December 4, 2014

Project Name: The Forefront at Thompson's Point Amendment Phase 1A Plan
Project ID: PEZ 2014-120
Address: 1 Thompson's Point CBL: 201 A005
Applicant: Chris Thompson, Forefront Partners I, LP
Planner: Christine Grimando

TO: Christine Grimando, Planner
FROM: David Senus, P.E. & Ashley Auger, E.I.T.
DATE: August 19, 2014
RE: Forefront at Thompson's Point-Phase 1A, Amended Level III Site Plan Application

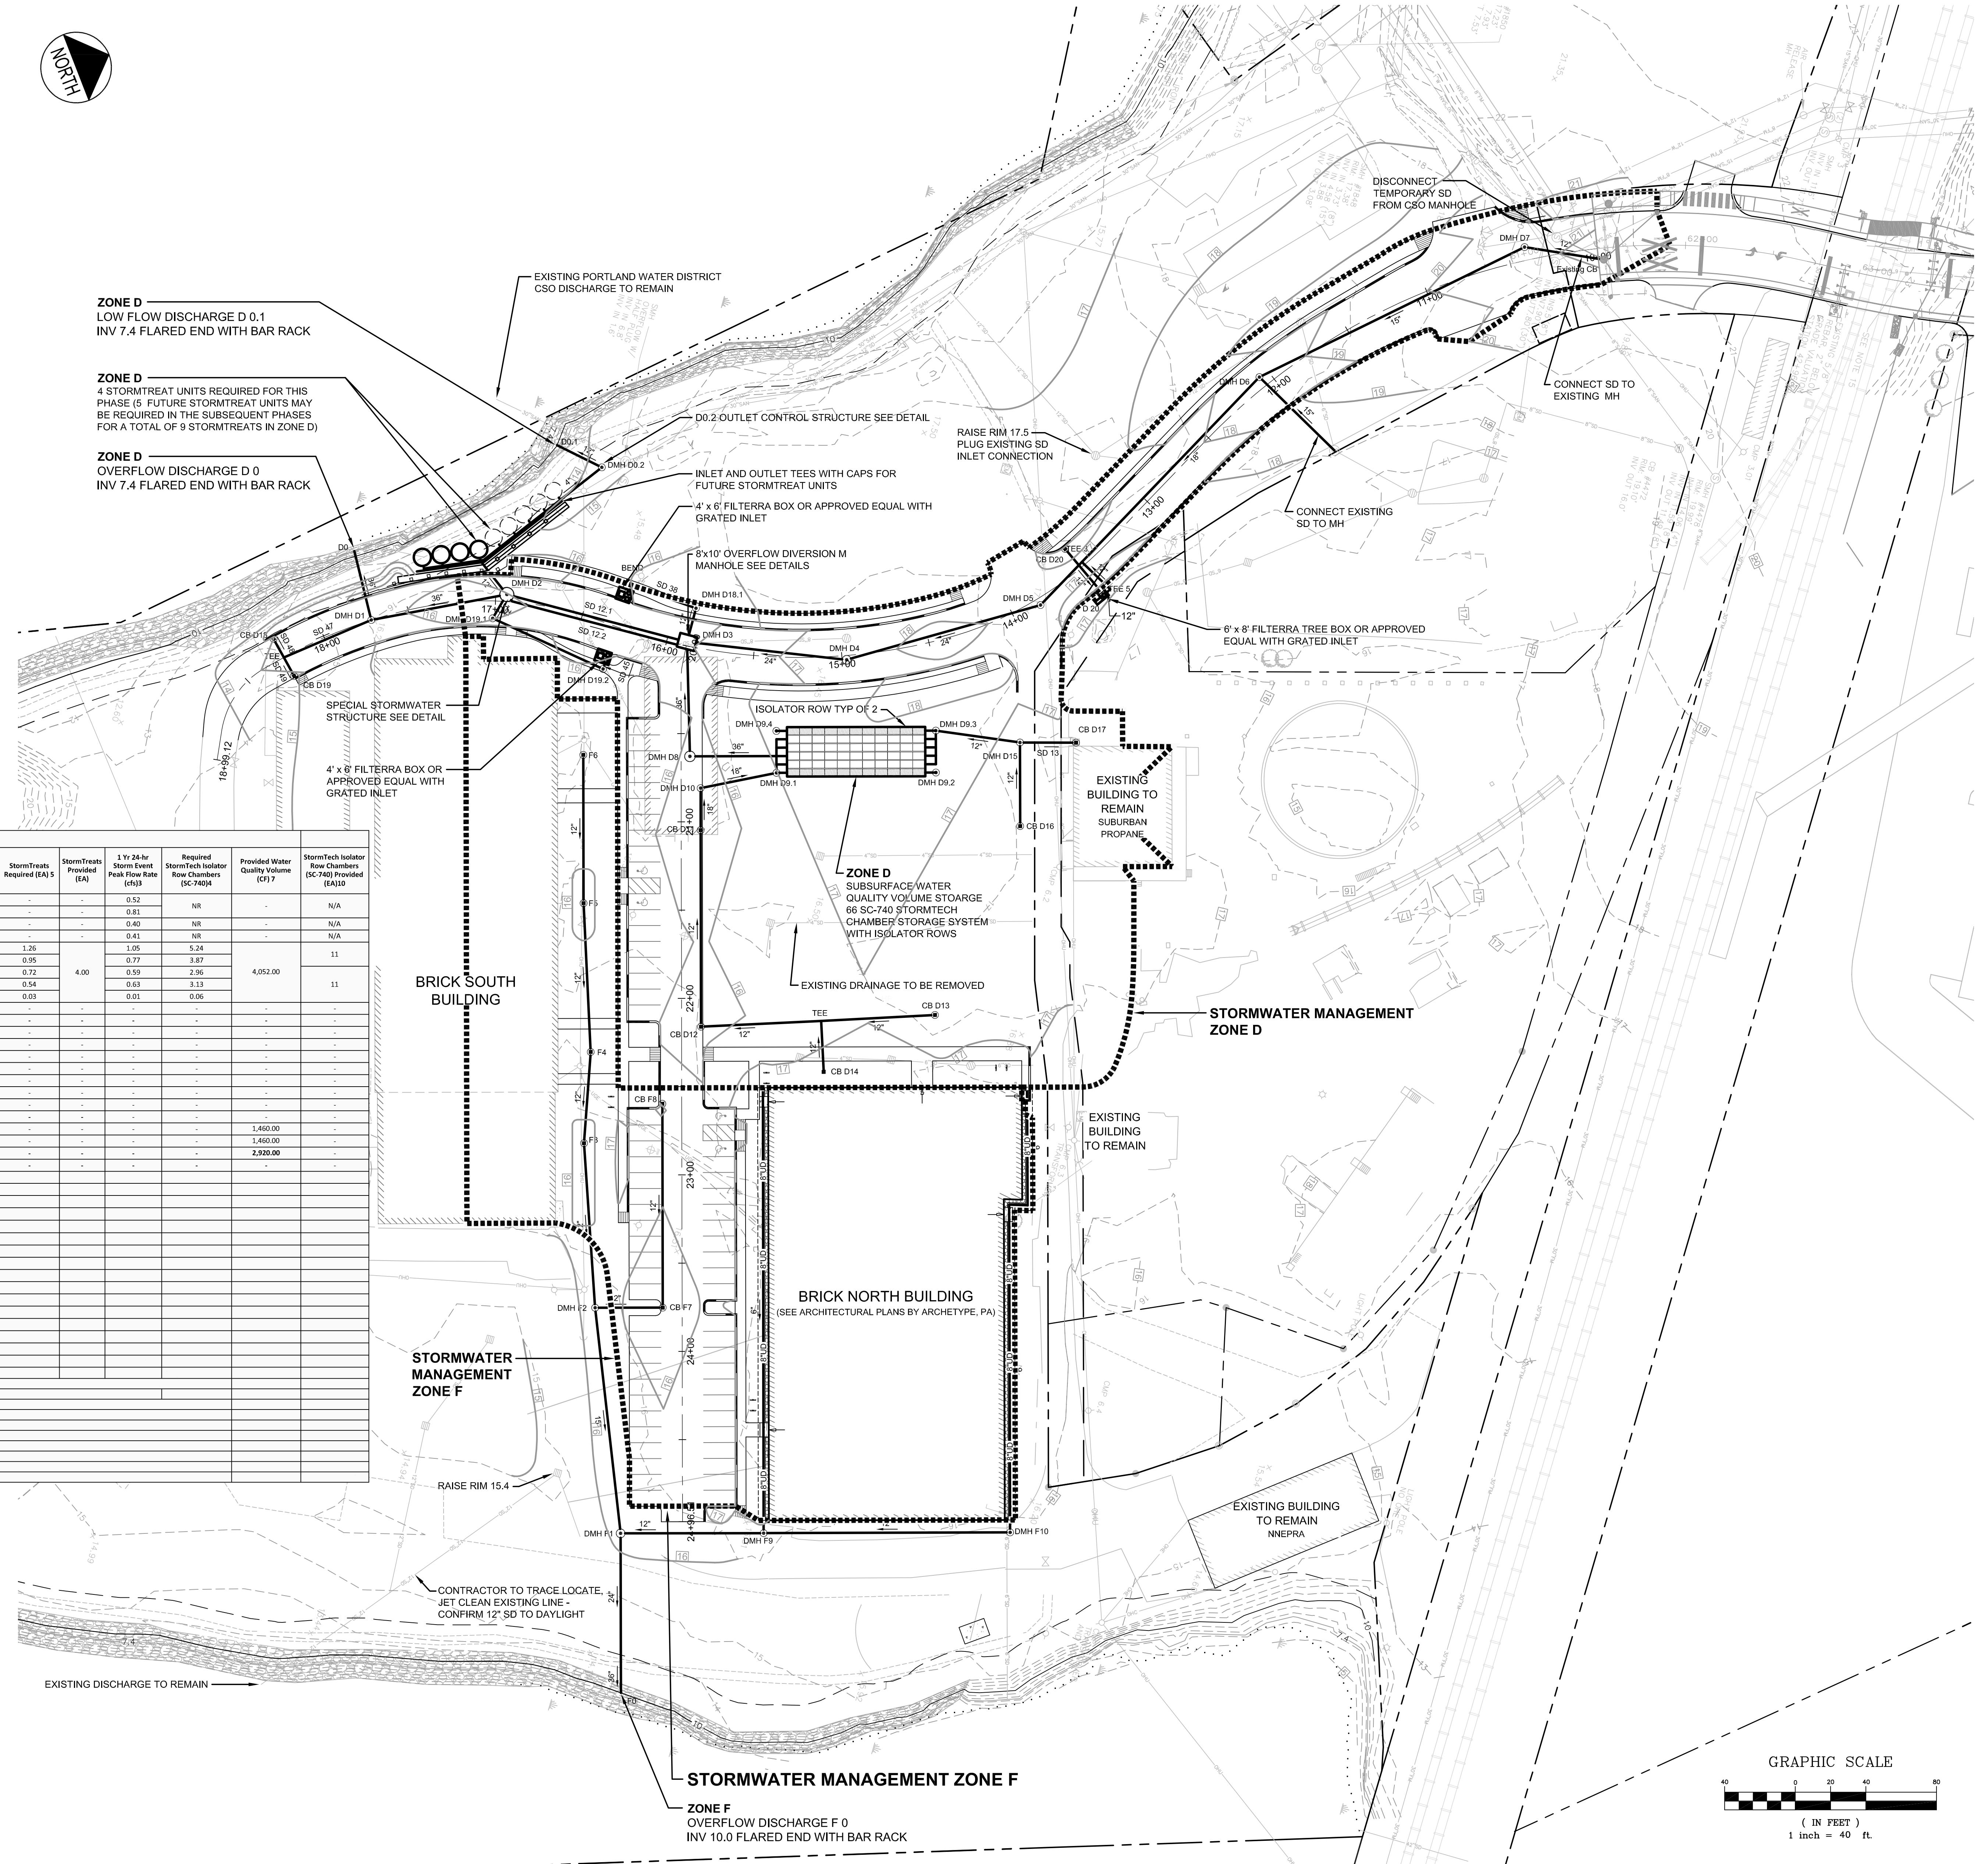
1. Future phases of work in the vicinity of the outfall associated with "Stormwater Management Zone F" (as depicted on sheet C-5.1) shall incorporate water quality treatment measures that provide adequate treatment capacity for runoff from the untreated parking lot south of the Brick North Building in accordance with the General Standards of Section 5 of the City of Portland Technical Manual. If no future work occurs on the site, water quality treatment measures for the untreated parking lot south of Brick North are not required.
2. All conditions from prior approvals regarding the site plan in its entirety continue to apply until superseded by an approved alternative.

2. Note 2 on Sheet C-5.1 refers to a Stormwater Management Operation and Maintenance Manual, which does not seem to have been provided at this time; the Manual should include a stormwater inspection and maintenance plan developed in accordance with and in reference to MaineDEP Chapter 500 guidelines and Chapter 32 of the City of Portland Code of Ordinances.

1. **Comment from Previous Memo:** "Woodard & Curran recommends including a condition of approval requiring that future phases of work in the vicinity of the outfall associated with "Stormwater Management Zone F" (as depicted on Sheet C-5.1) incorporate water quality treatment measures that provide adequate treatment capacity for runoff from the untreated parking lot south of the Brick North Building in accordance with the General Standards."

We recommend continuing to include this as a condition of approval or stating it as a future requirement in the Approval letter. As noted by the Applicant in the June 30, 2014 Supplemental Stormwater Management Report "Ultimately, as part of the Master Plan Stormwater Management Strategy, the parking area to the south of Brick North will be conveyed to a StormTreat™ treatment system". The City, as the reviewing authority for Chapter 500 Stormwater compliance, requires that the parking lot area south of Brick North receive treatment in accordance with the approved Master Plan. The proposal to treat the roof water under this phase to meet the general standards is acceptable; however, long term plans should include treatment of the parking lot area.

**WATER QUALITY TREATMENT DRIP EDGE DETAIL
CONDITION 1 - LANDSCAPE AREAS**
N.T.S.

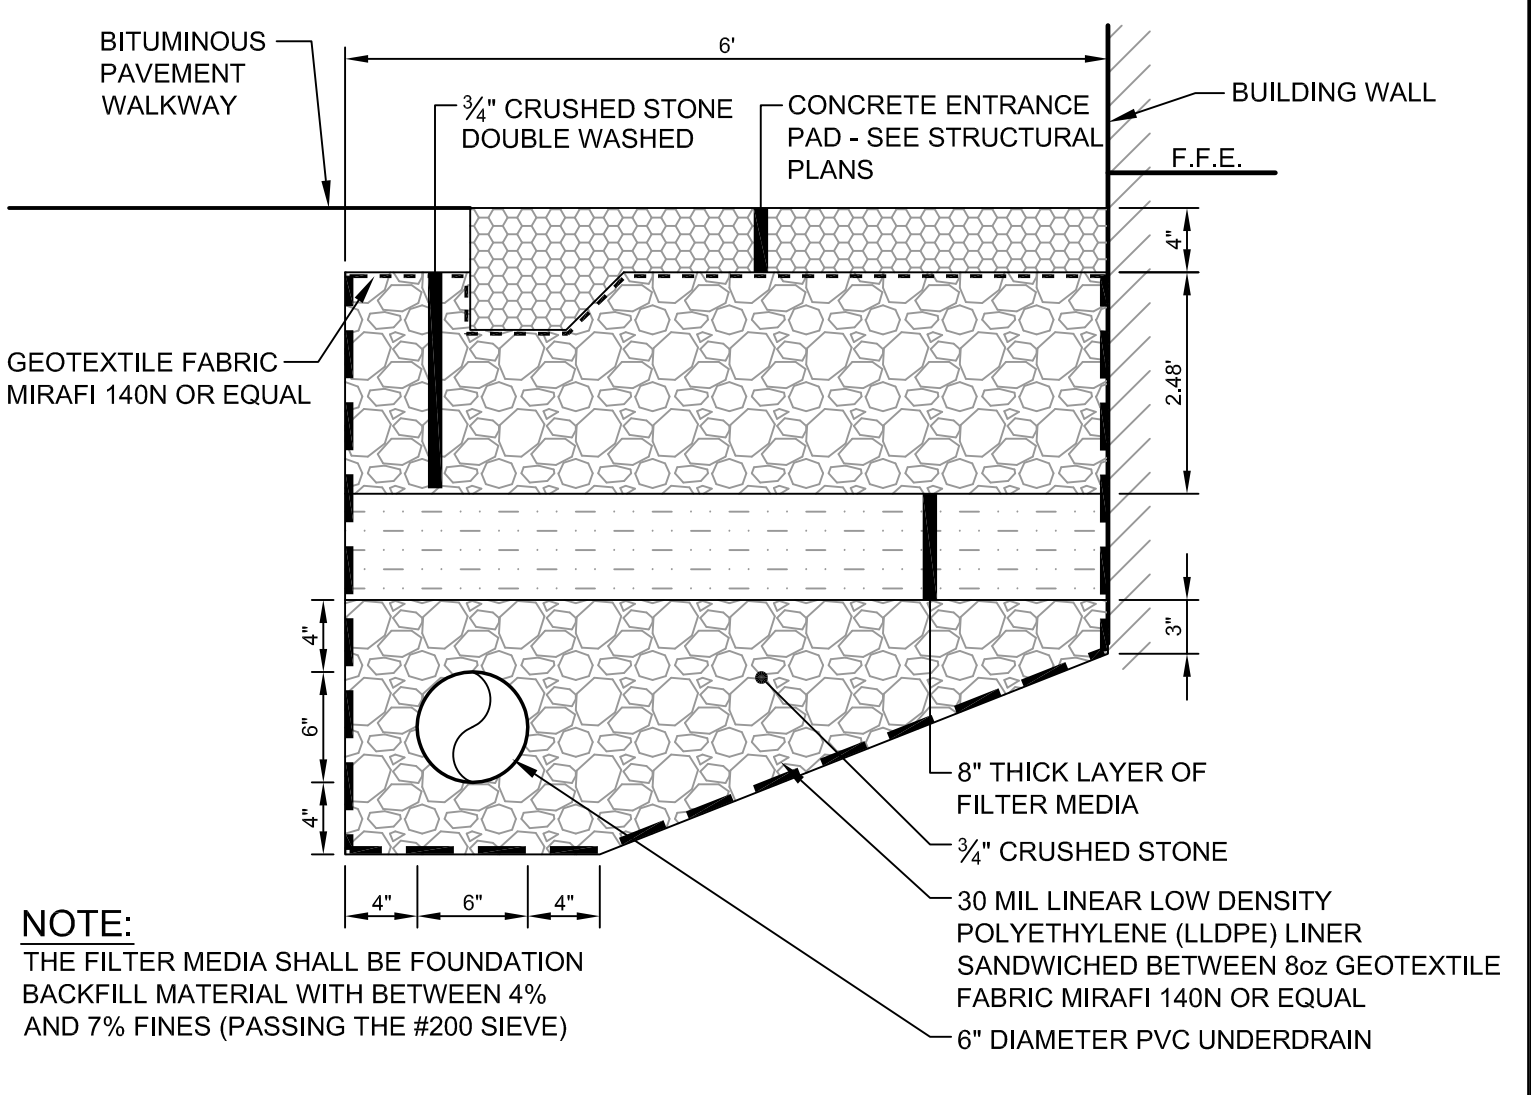
6. Per Chapter 7.6 of Volume III of the MaineDEP Stormwater BMP Manual:
 - A. The Applicant should provide calculations demonstrating that the proposed Water Quality Treatment Drip Edge reservoir has been properly sized; and

- B. The underdrain bed should be wrapped with geotextile fabric if utilizing $\frac{3}{4}$ " crushed stone as underdrain bedding (as proposed) to avoid fines washing into the bed from the filter layer.

Drawing file: 5. Final Approved Plans and Documents / L-1.0 Stand Alone Brick North Landscape.pdf

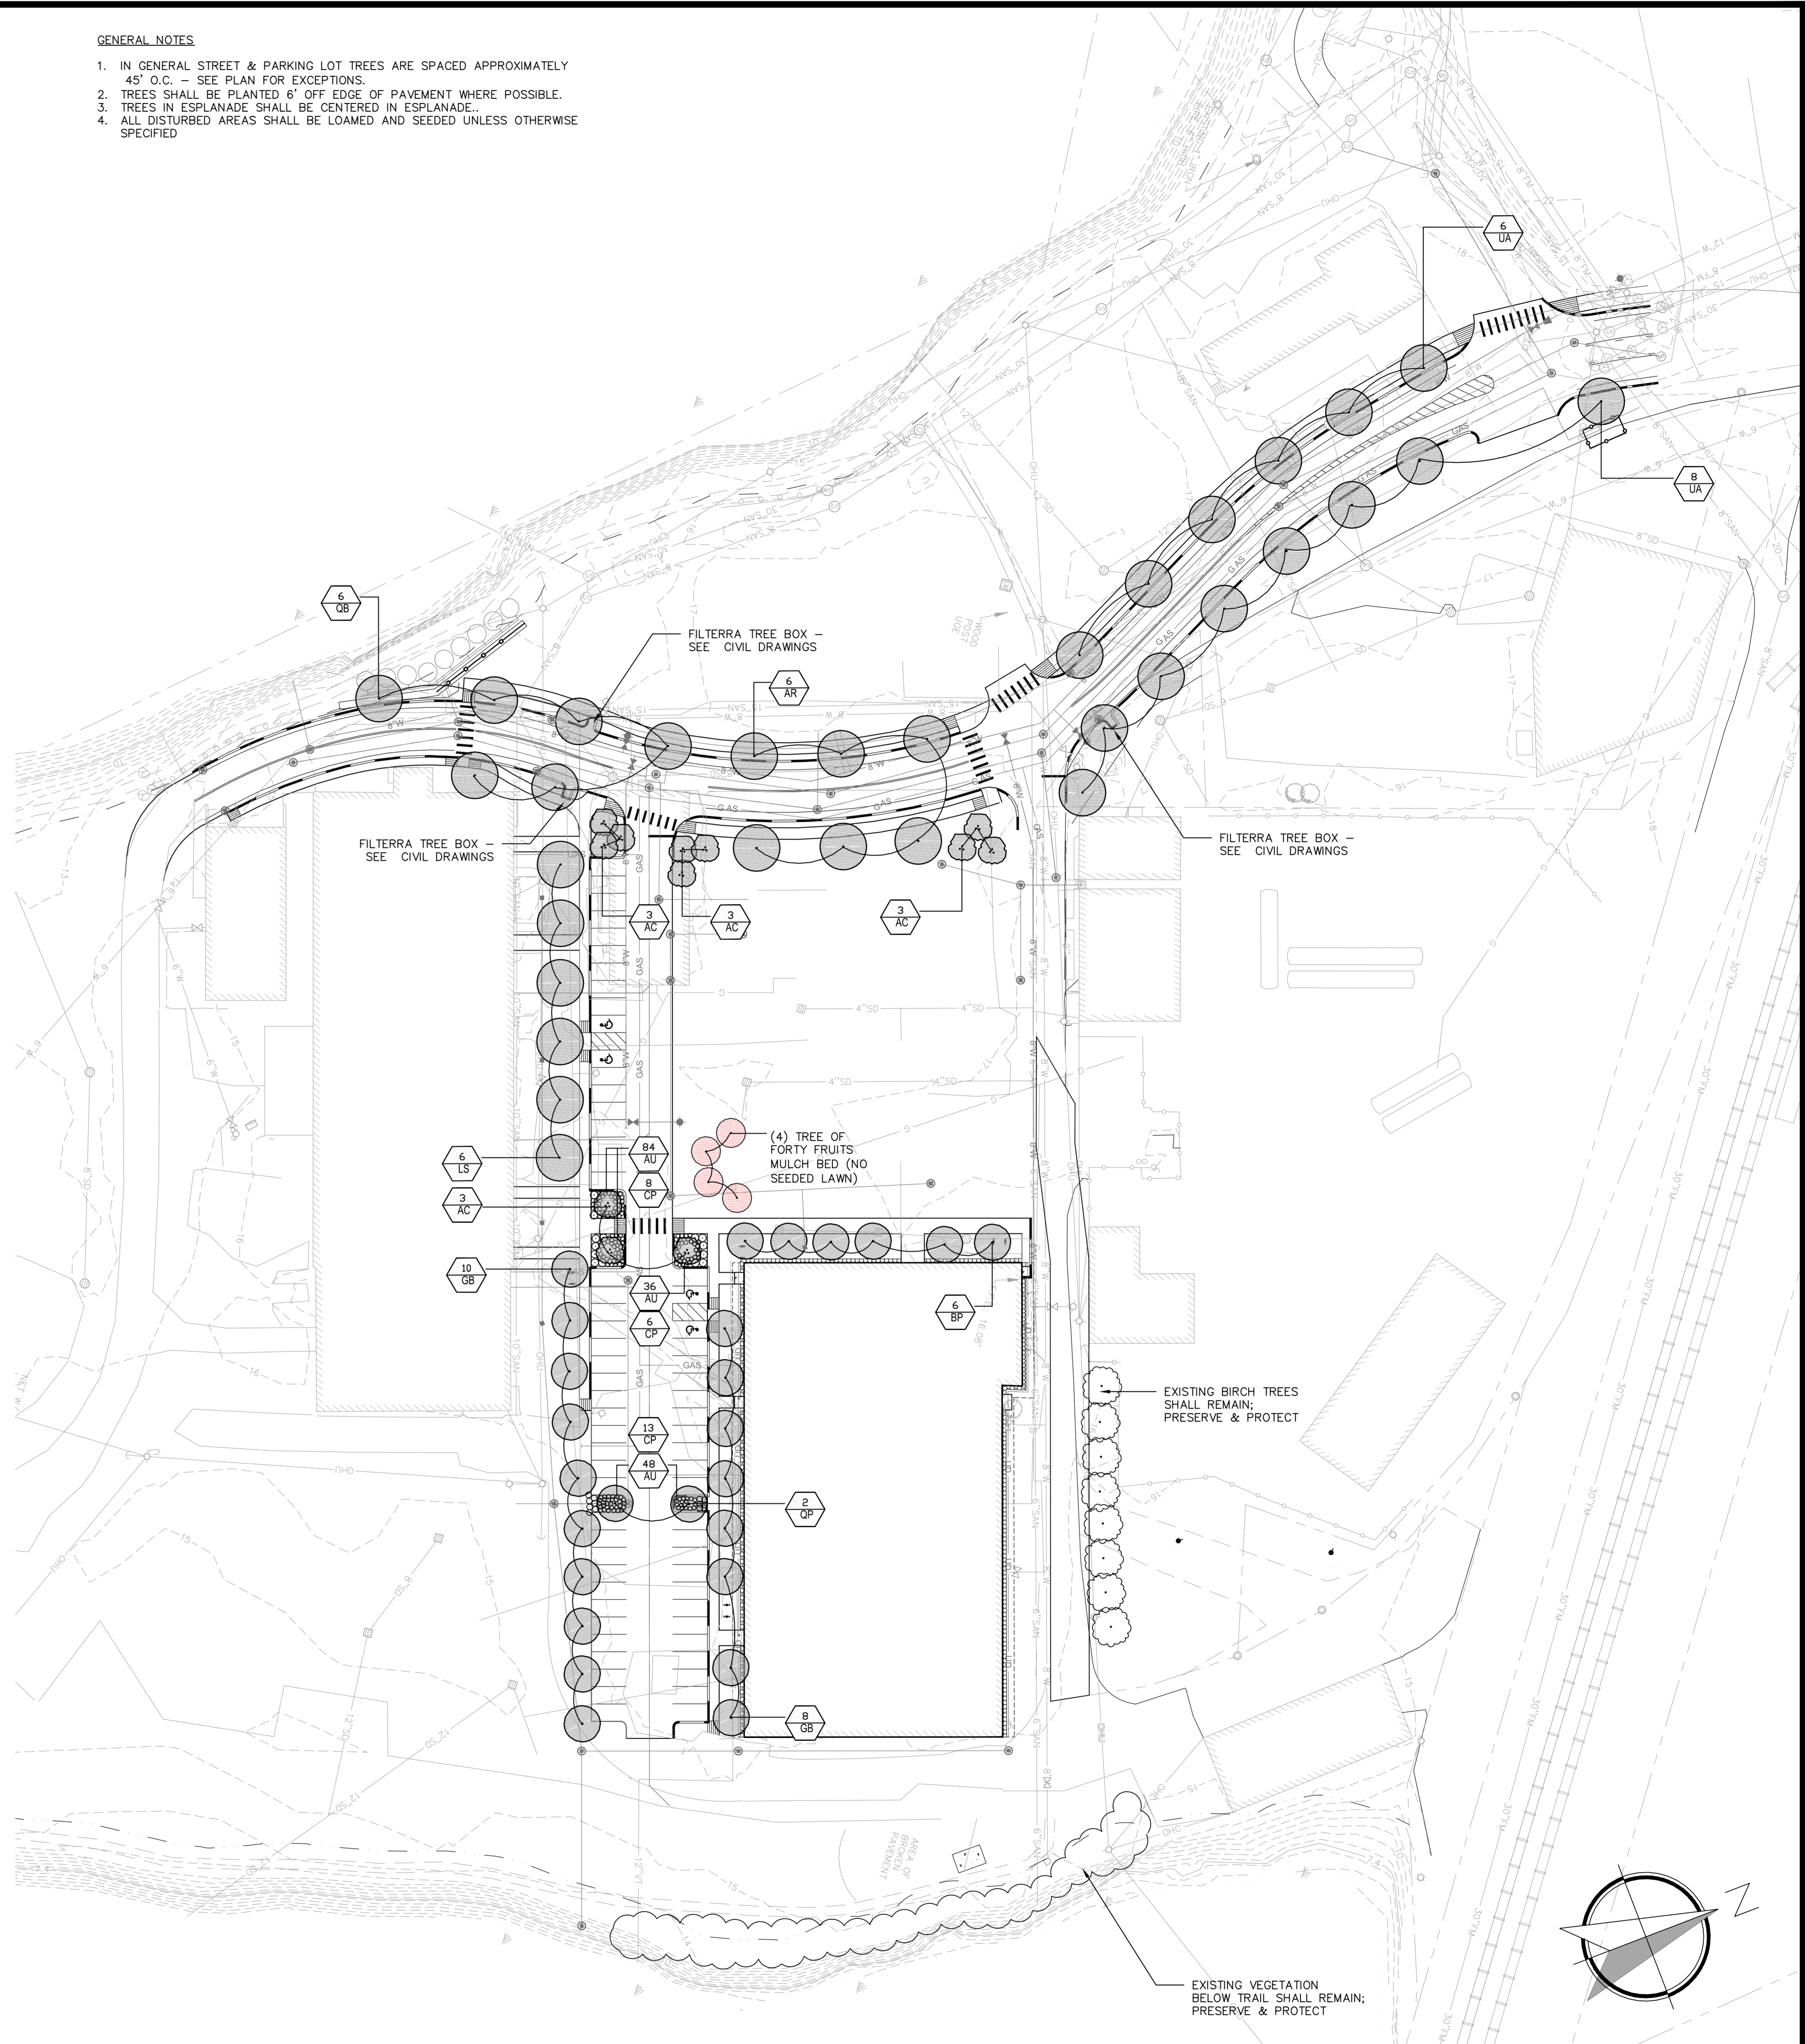
In review of the Thompson's Point landscape plan as shown on sheet L-1.0 I have the following comments and recommendations:

a) Street & Parking lot tree planting - the design as shown on Sheet L-1.0 offers the framework needed for the Thompson's Point project. Uniform spacing and grouping of tree types help reinforce the desired elements of shading pavement areas, directing traffic flow and beautification.

Recommendations - 26 'Princeton' American Elms <http://princetonamericanelm.blogspot.com> are proposed to be used for the entrance drive, despite being a great shade tree and 'resistant' to Dutch Elm Disease (DED) we should caution the planting of 26 down to perhaps the first 14 trees at the entrance and consider other shade / street tree options. On Portland's Eastern Promenade we have planted Princeton Elm in blocks since 1994 with good results until one recently died due to DED, thus the word of caution. Other tree options include: Swamp White Oak, Chestnut Oak, Red Maple...

b) Parking lot landscape - As mentioned above that trees are proposed for the drive and parking lot area the overall landscape should be checked to ensure it meets City parking lot standards. At this time it appears to be in need of additional landscape features - shrub planting particularly in the end of the lot nodes and between parking rows. This includes the space between the drive and the parking lot and within the parking lot where the Pin Oaks are proposed.

Recommendations - Additional shrub planting should be considered in the parking lot nodes and between the roadway and parking lot. These recommendations would be to meet the City parking lot landscape standards. As with past Thompson's Point landscape recommendations, native plants are strongly encouraged. This could include Bayberry and Comptonia.
